**RE: DFT Review Comments for Route 66 Flats (7600 Central Ave SW)**  
**Project Number: PR-2023-008589 aka (PR-2024-009904)**  
**Application Number: SI-2024-000136**

On behalf of High Desert Housing and BlueLine Development, thank you for your Site Plan review of the new affordable housing community located at 7600 Central Avenue SW.

Please see the attached comment responses to Plan Review #2, if there are any questions pertaining to the responses, please let us know- Thank you Taylor Bissert.

1 COURTYARD WEST ELEVATION
3/16" = 1'-0"

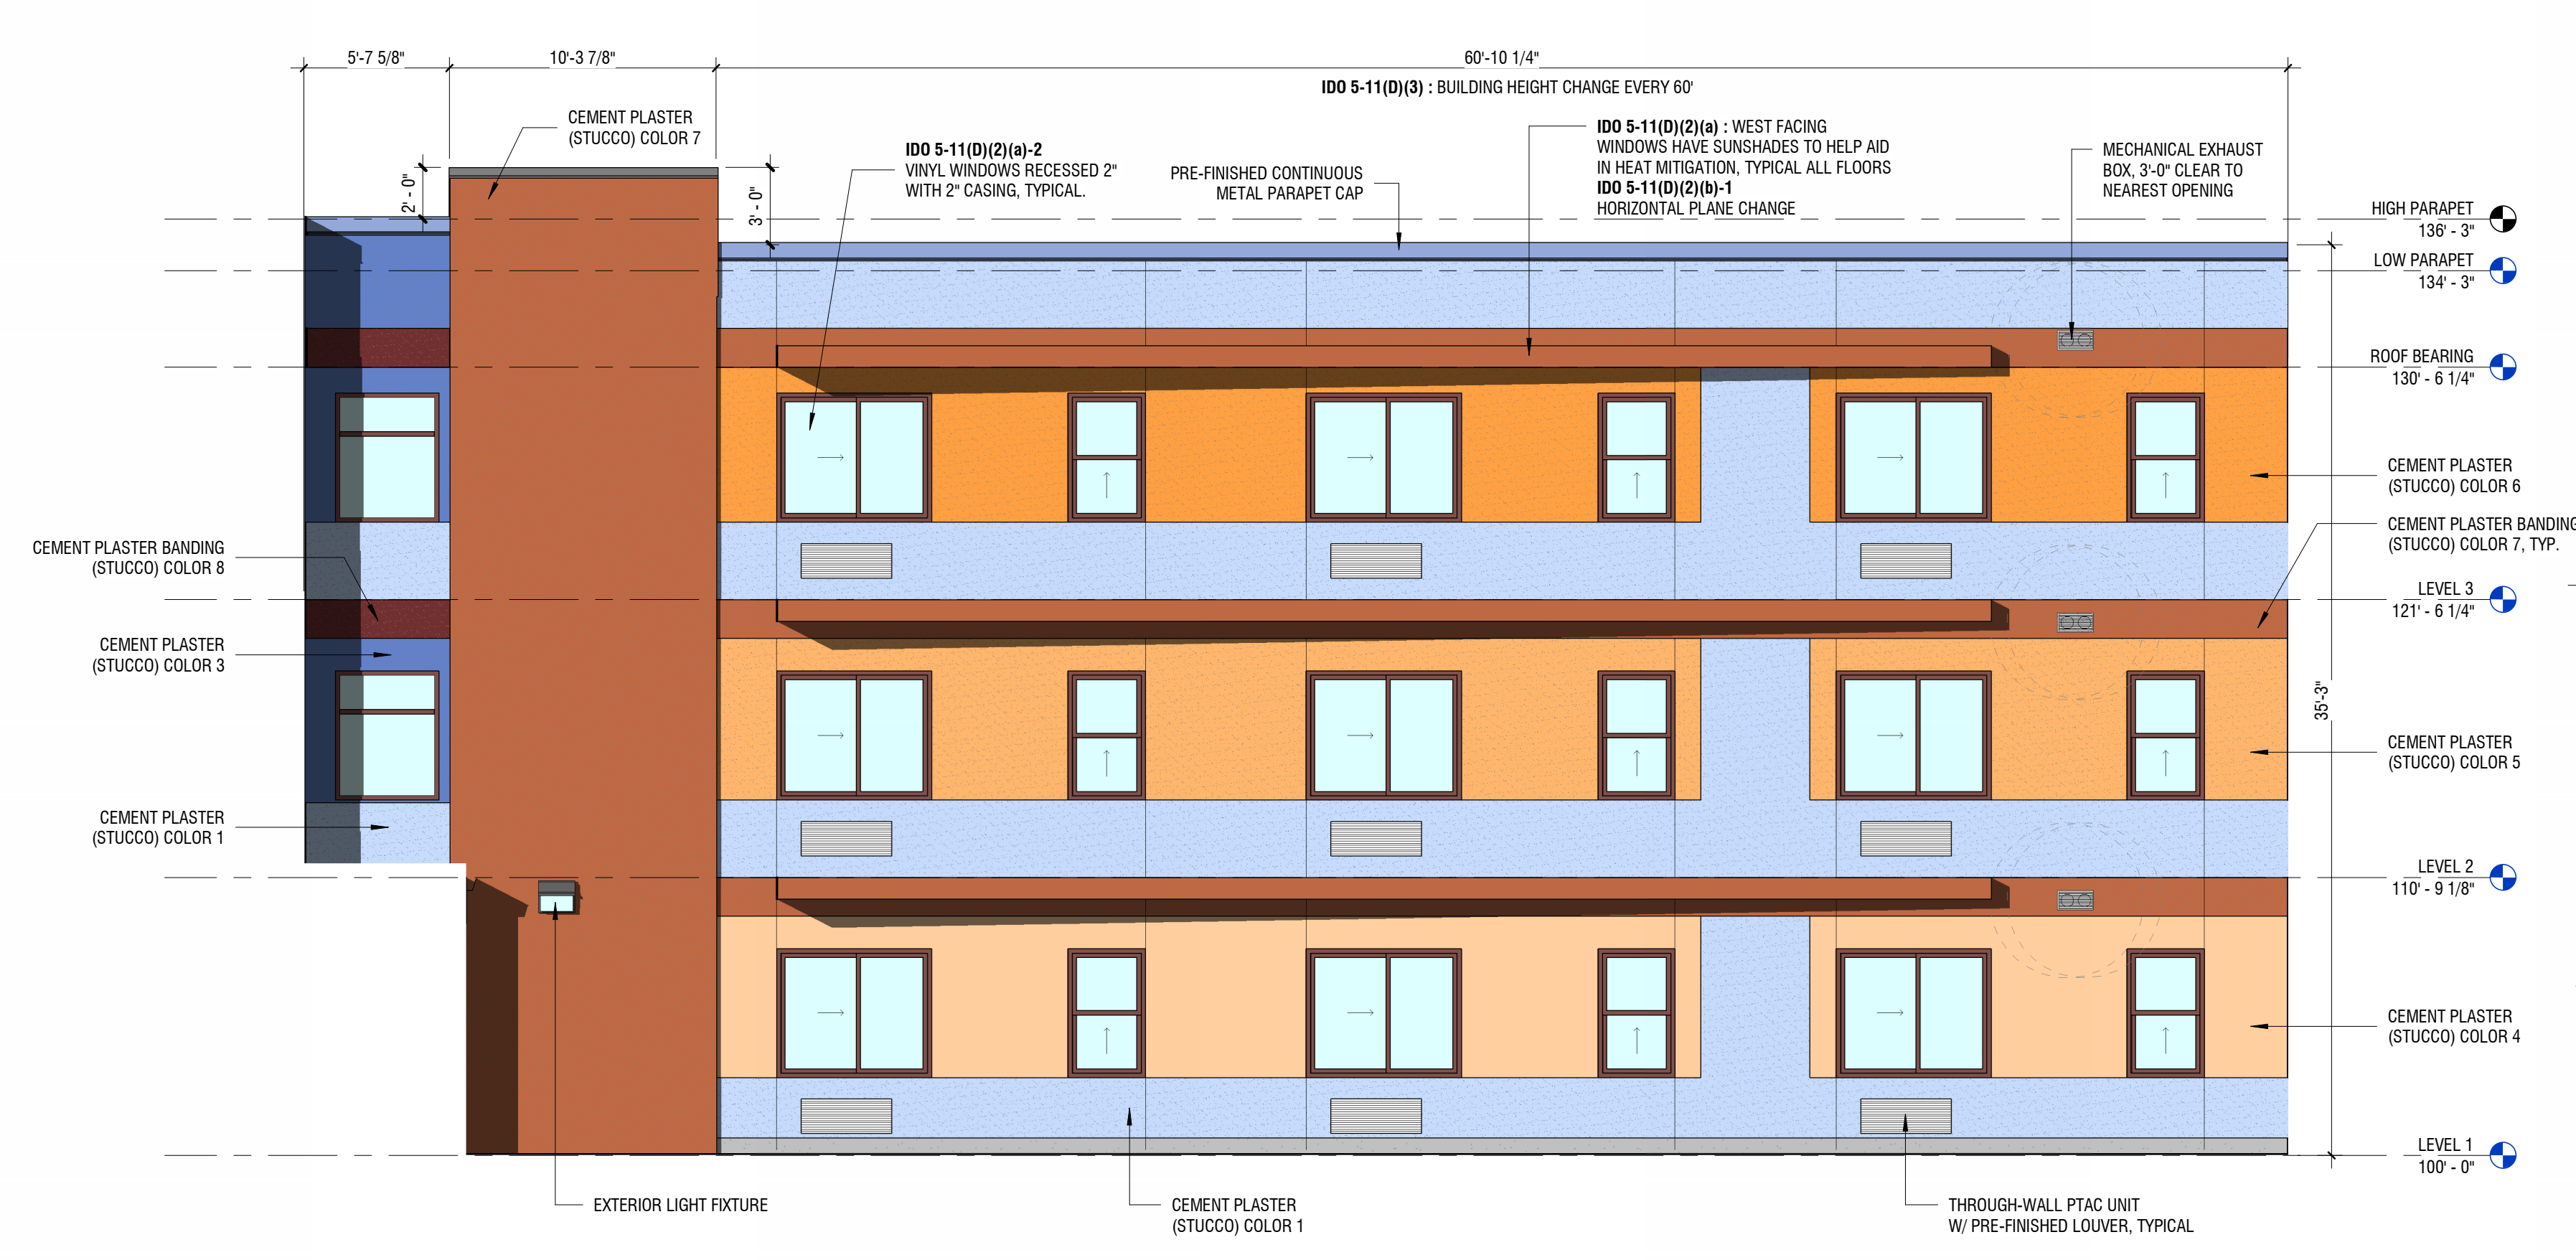
1. The façade shall have at least one element that is recessed or projected from the façade by at least 6 inches and that is 2 feet in width for every 30 feet of facade length. Please make proper changes to comply with this code. *(SW Response) - Hannah Aulick agrees the canopies meet articulation requirement for the Courtyard West Elevation and the other side and front elevations previously met requirement.*

Rooflines longer than 60 horizontal feet shall include at least one vertical or horizontal elevation change of at least 2 feet. Roofs with a pitch of less than 2:12 shall be screened by a parapet wall. Please make proper changes to comply with this code. *(SW Response) - rear roofline updated to meet requirement, Courtyard West Elevation 60'-10 1/4" length approved by Jolene Wolfley*
